VA-23-00004 Kosar

TO: All Staff
FROM: Public Works Plan Review Team
DATE: March 30, 2023
SUBJECT: VA-23-00004 Kosar

Re: VA-23-00004 (Kosar Setback Variance)

Site Sketch / As-Built Drawing

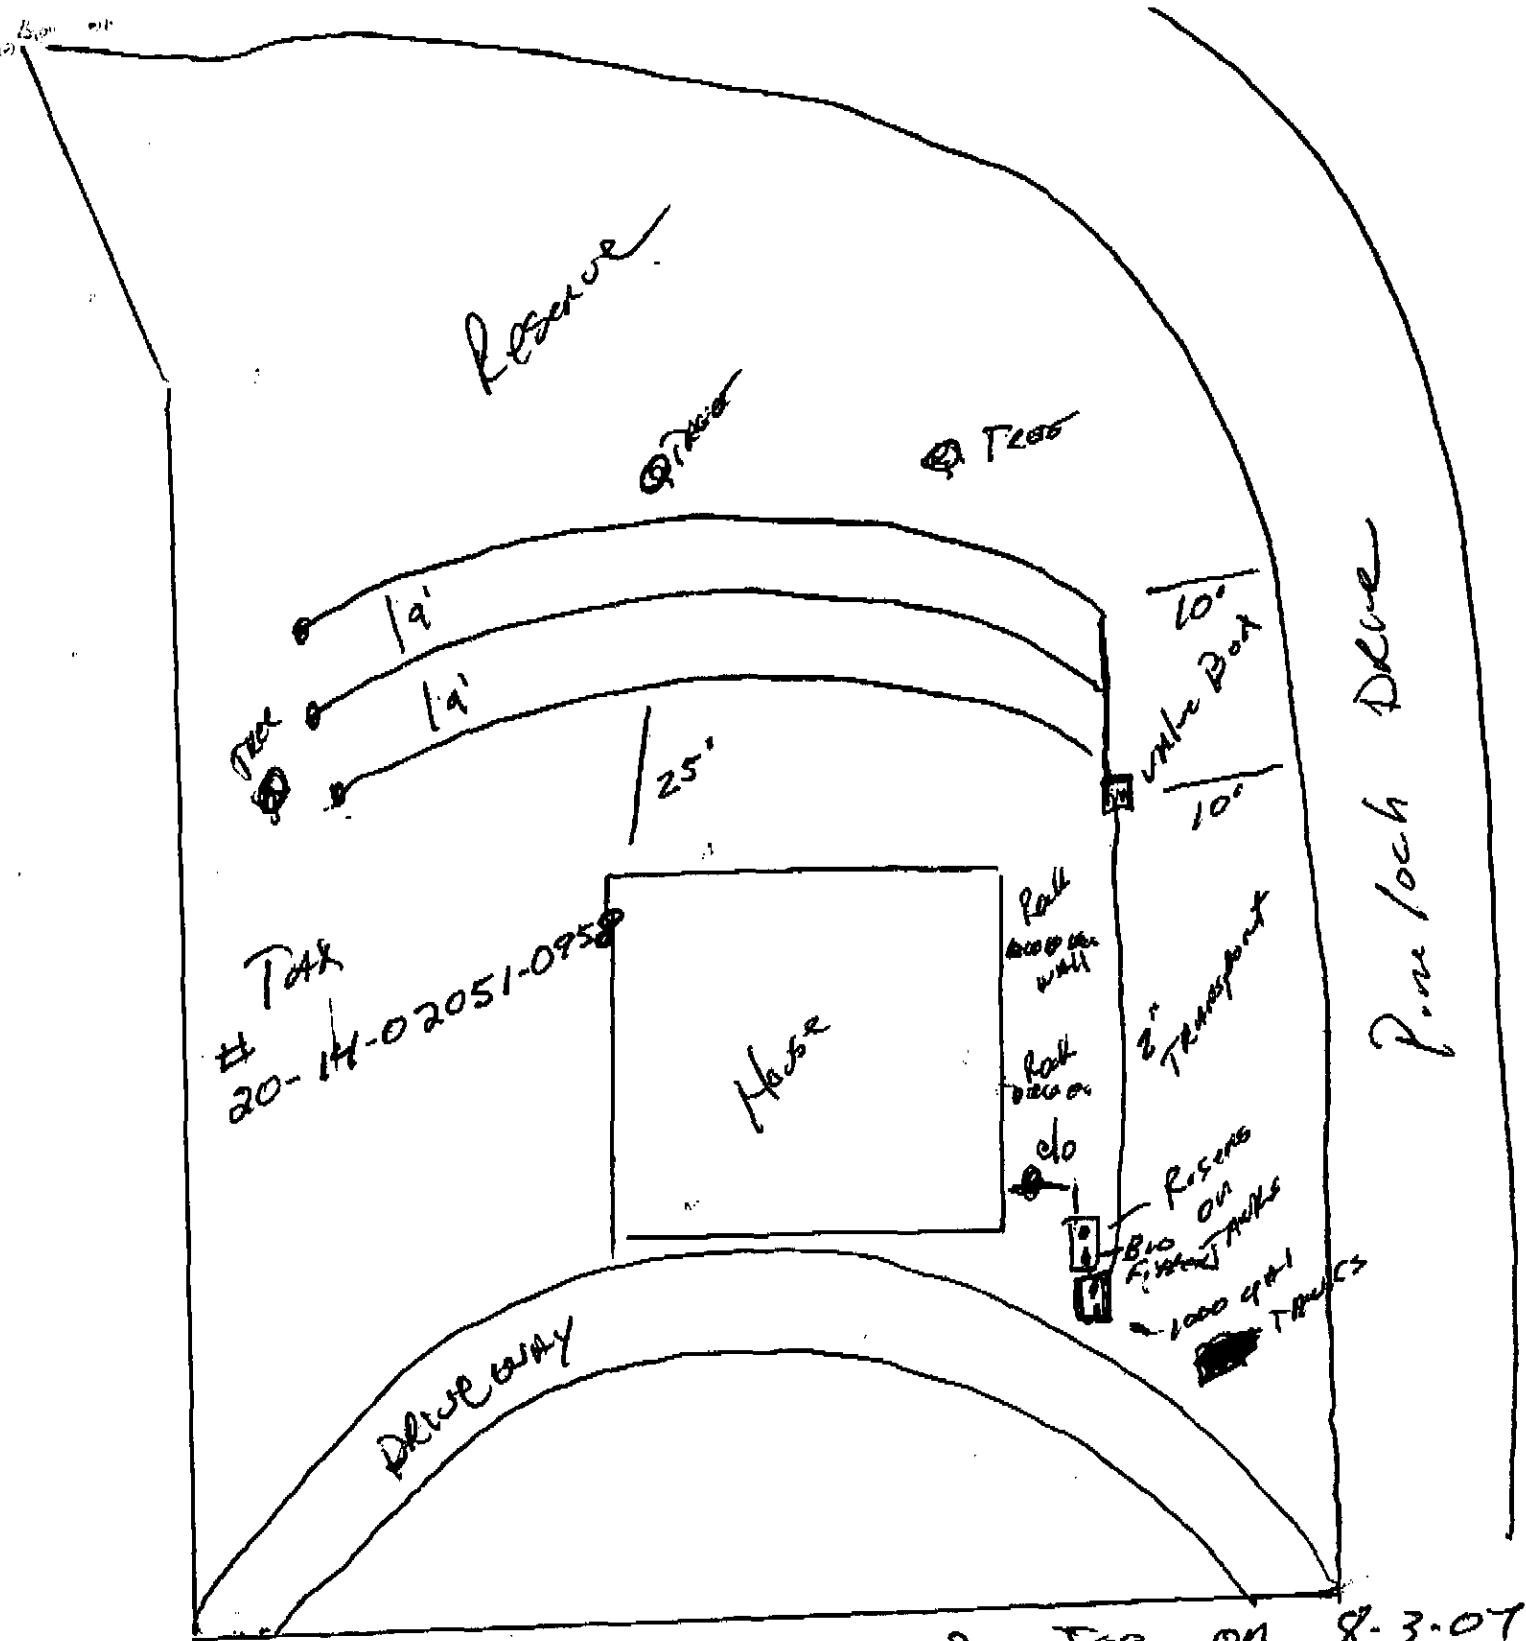
The current septic system and designed listed reserve area is where the proposed garage will be. KCC 13.04.080, requires that no impervious surface be placed above an on-site sewage disposal system or a reserve area.

The applicant will need to propose a smaller structure or a new location.
